Application for a Non-Material Amendment Following a Grant of Planning Permission

Removal of single storey rear projection. Construction of single storey rear extension. Alterations to 2 front dormers to make into 1 dormer.
Change position of
front door. New ground floor front and rear windows

3/23/0653/HH

New window to be fitted in side elevation of approved extension. Noted in Revision cloud on drawing

DISCLAIMER NOTE

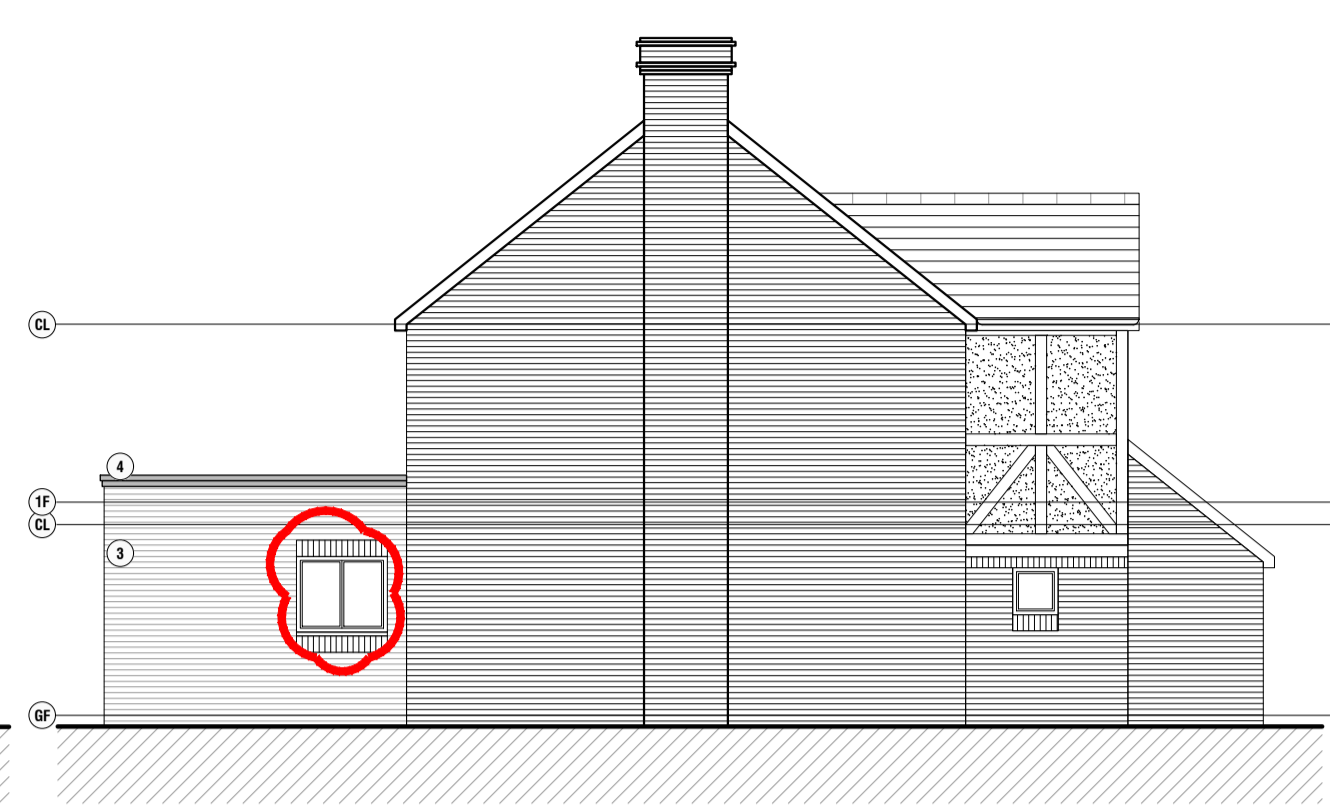
3665-23A1-03C PROPOSED PLANS AND ELEVATIONS

3665-23A1-03D PROPOSED PLANS AND ELEVATIONS
